PRE-APPLICATION ENQUIRY DC/21/00984

Land North Of Pound Hill Cottage, Pound Hill, Great Bricett, IP7 7DN

Pre-application Enquiry

Written response - Erection of 4no. semi-detached dwellings with associated outbuildings and change of use of land utilising existing vehicular access.

PROPOSED SITE PLAN 1/200 (A1)

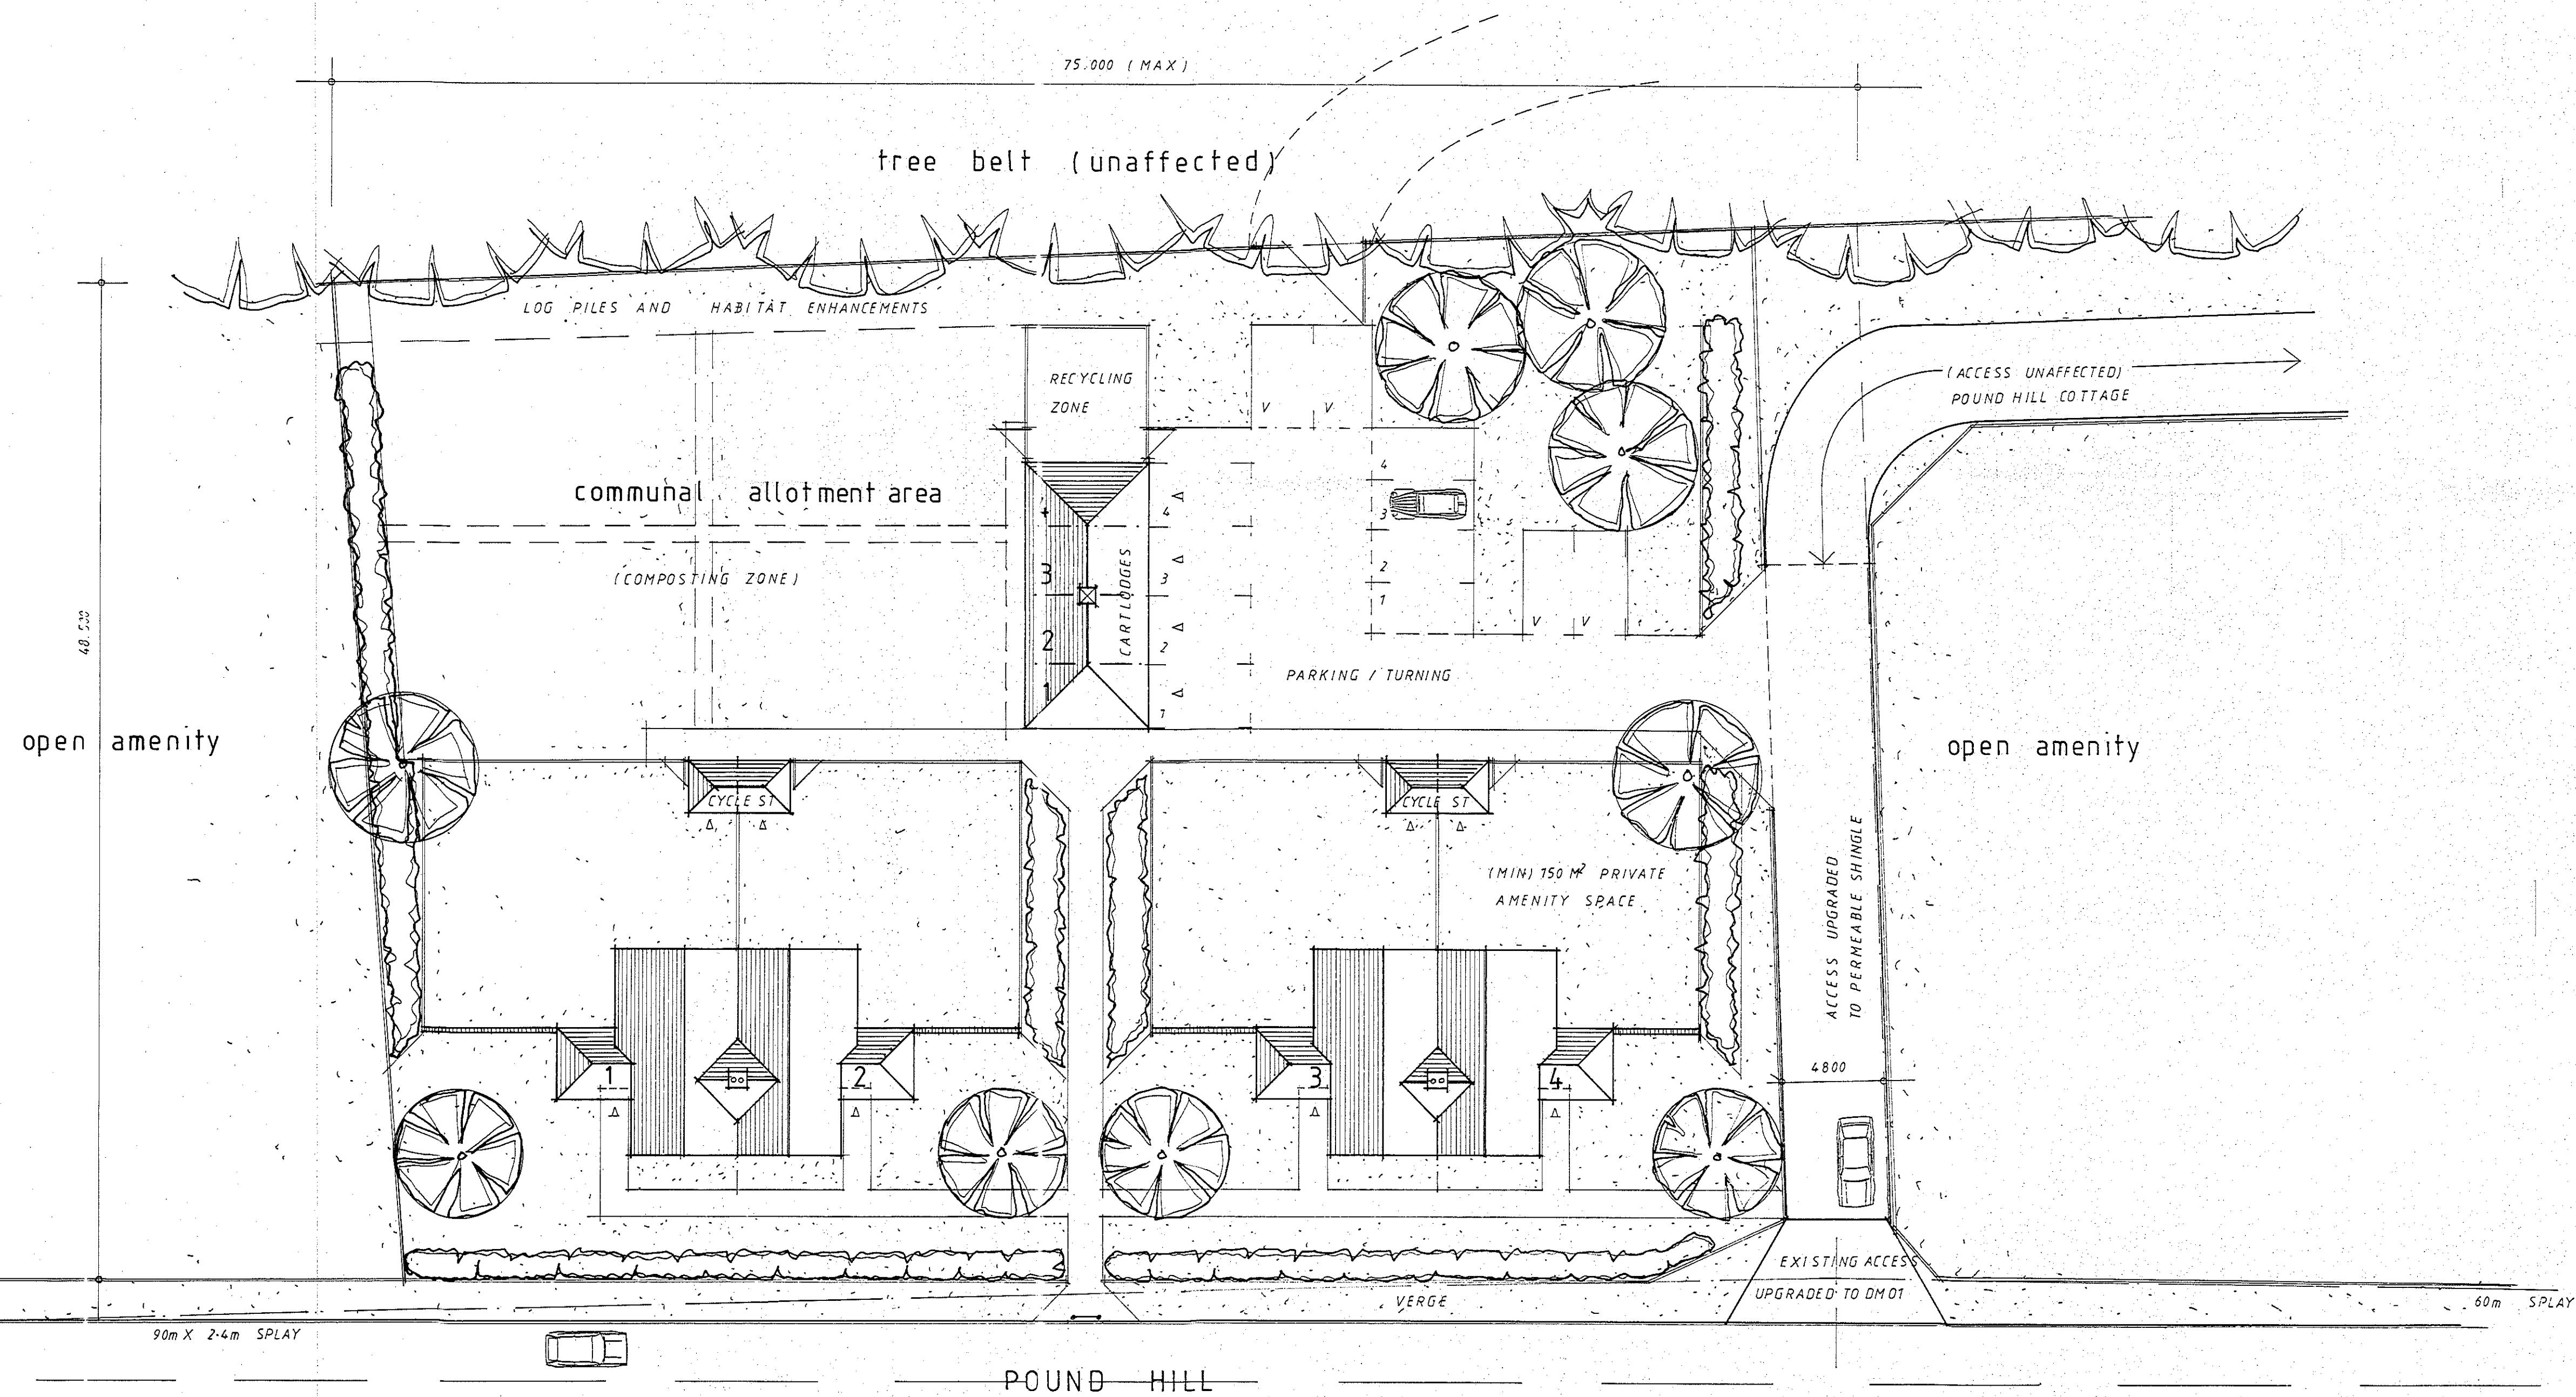
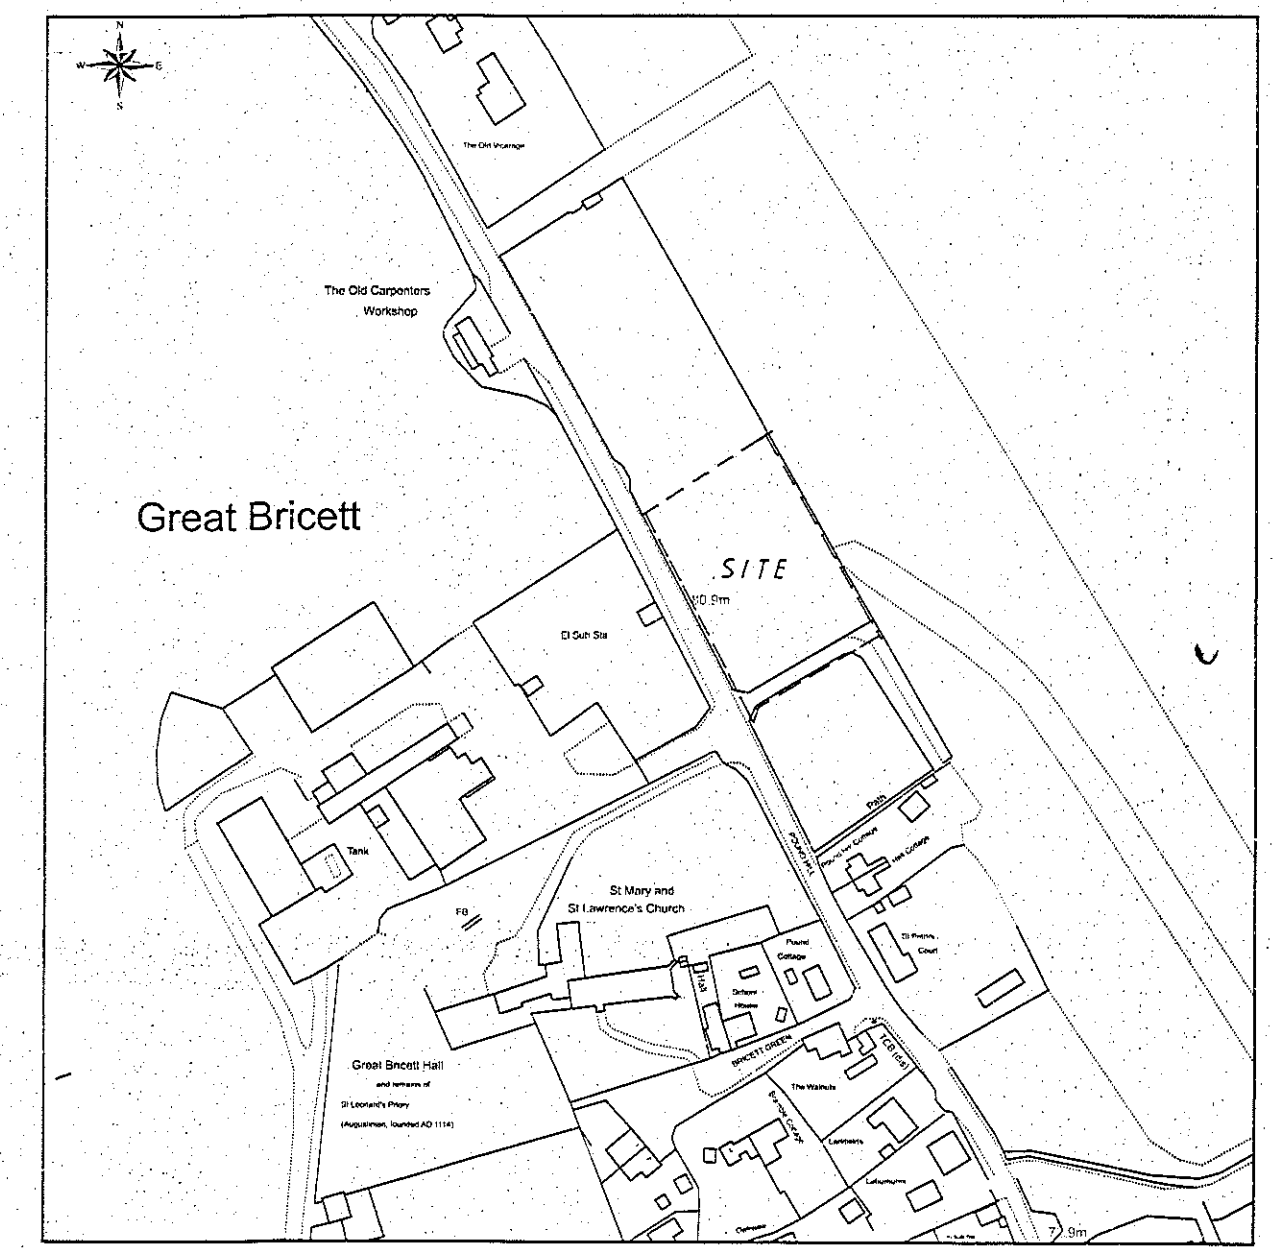
Utilising an existing access is likely to be considered acceptable, however based on the intensification of use works will likely be required to increase the width of the access, surface it appropriately and ensure there is adequate visibility splays. A block plan should show all of these details.

Adequate parking provision will need to be provided on site in accordance with SCC Parking Guidance (2019) [Parking guidance | Suffolk County Council](#) this should be proportionate to bedroom numbers proposed. Bin presentation and storage areas should also be provided.

Landscaping on site should be sympathetic with the rural surroundings and should primarily comprise of soft landscaping using native species. Close boarded fencing would be unacceptable in visible locations.
